Your Ref: OWPC25077
Our Ref: FP/228/19/PL 21-10-2019
Please ask for:
Amber Willard

Retention of single storey timber side 'lean to' extension.
Oakland Court 26-28 Admiralty Road Felpham

EXISTING GROUND FLOOR PLAN

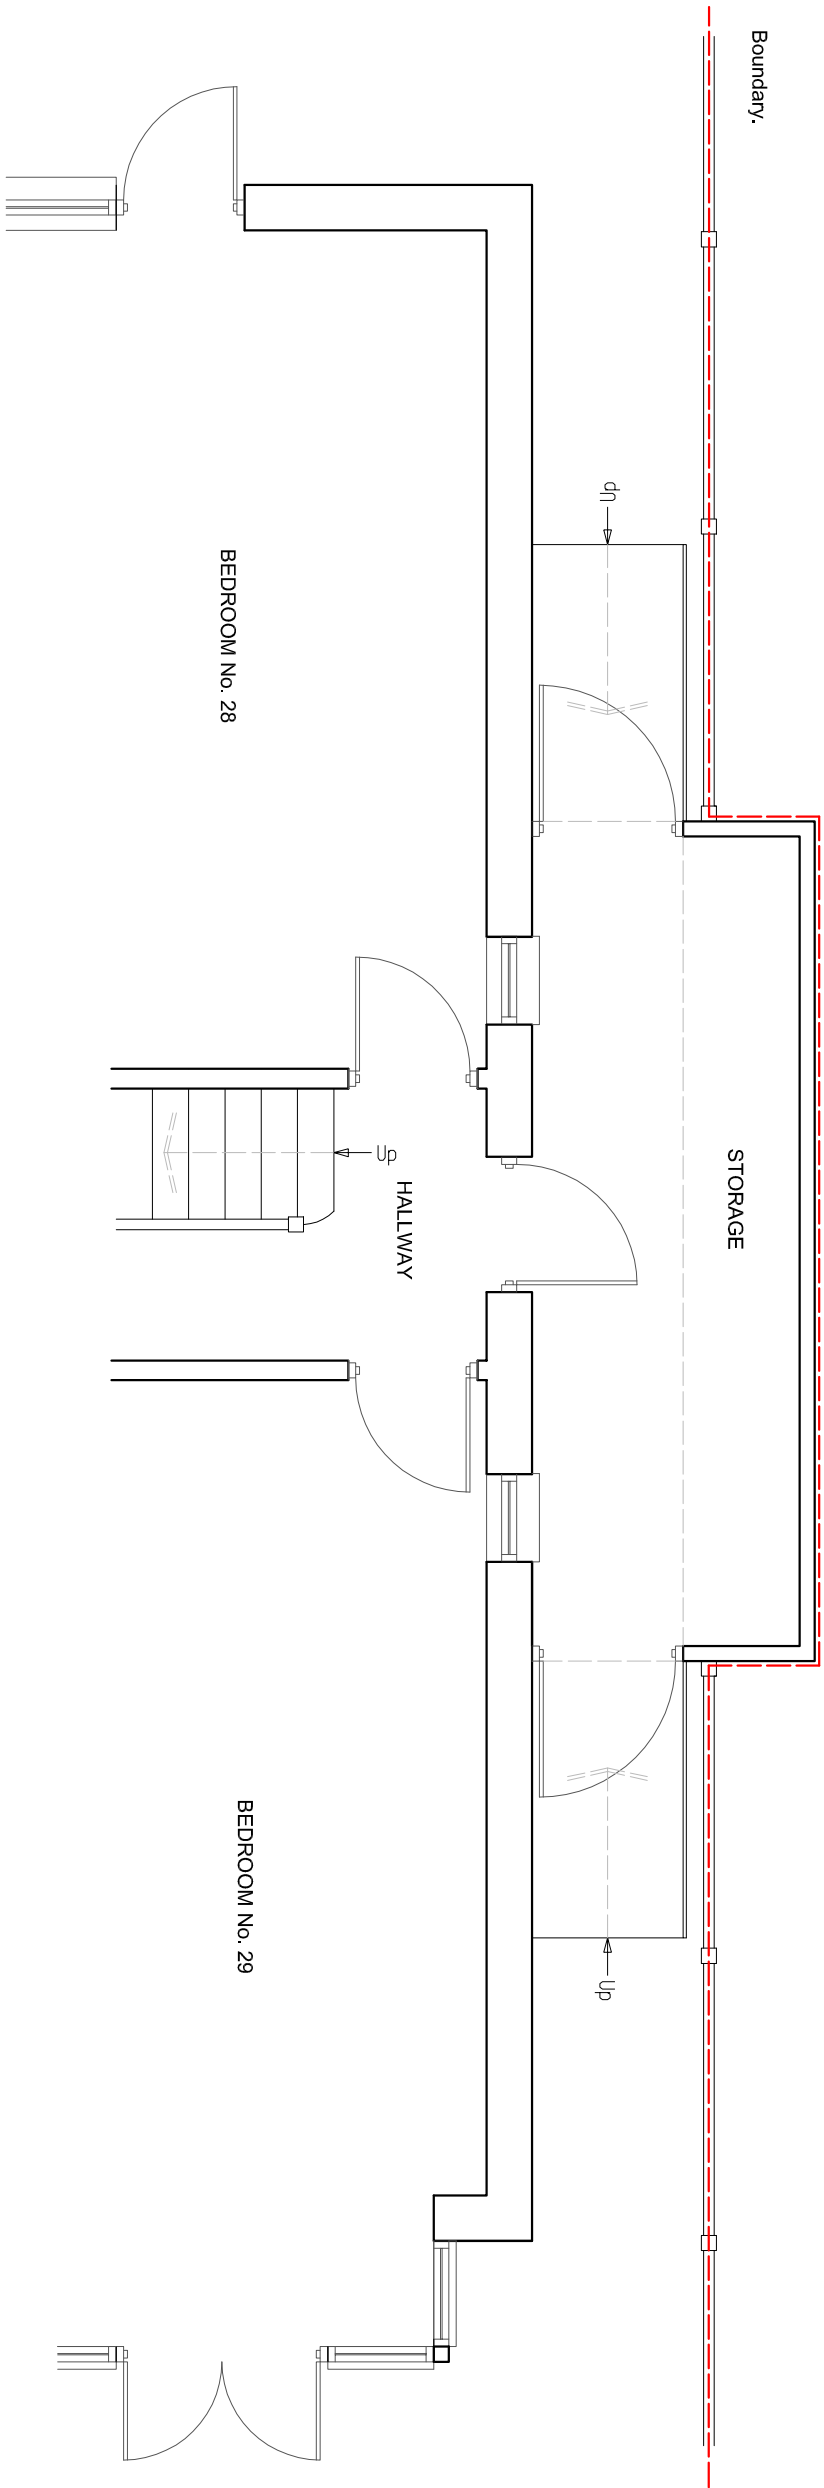
The structure in question was erected circa 2017 and extends to within millimetres of the boundary between our properties. It is approximately 18' in length running north/south along the boundary and is built into two dog-legs in the boundary, thereby giving the appearance of protruding into our garden. The roof slopes upwards towards our property, reaching a height of about 8' 3" on the boundary. According to the Title Deeds, Oakland Court is responsible for that boundary in its entirety, the remainder of which is fenced with standard panels to a maximum of 6' high.

EXISTING ELEVATIONS

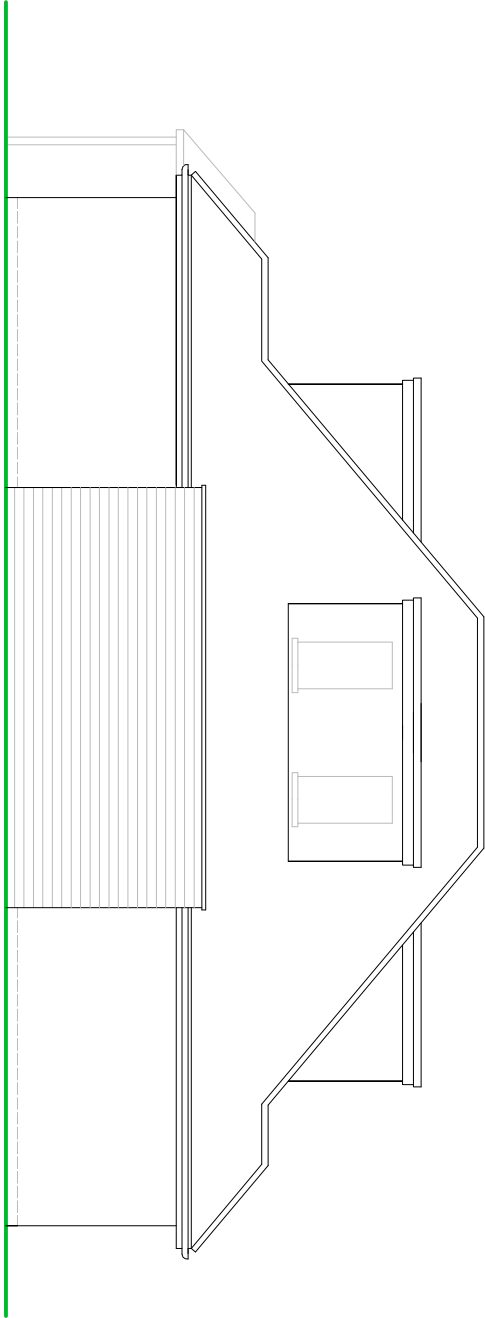
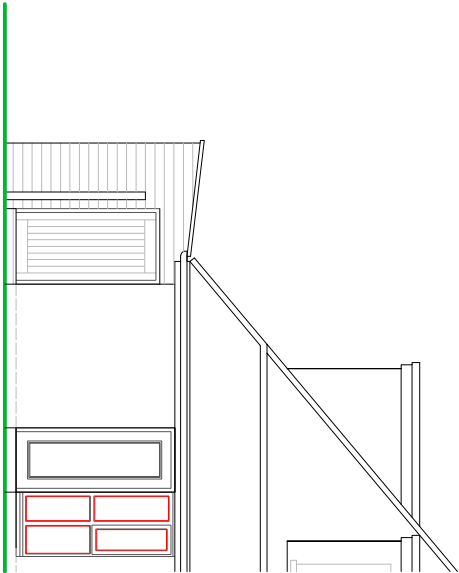
The lean-to is covered with a plain brown weather-resistant boarding, with some timber cladding to the small east/west side panels. As it stands there is no room for further decorative or protective cladding to be applied to the external surface of the boarding without it encroaching onto our property.

In principle we have little objection to some form of covered facility at Oakland Court to be used for storage or access. However, we do object strongly to the current presentation of the "lean-to" given its position within the dog-legs of the boundary. In particular we object to its proximity to the boundary, its height at the boundary and its intrusive appearance which is not at all in keeping with what one might reasonably expect from a boundary fence in a residential setting.
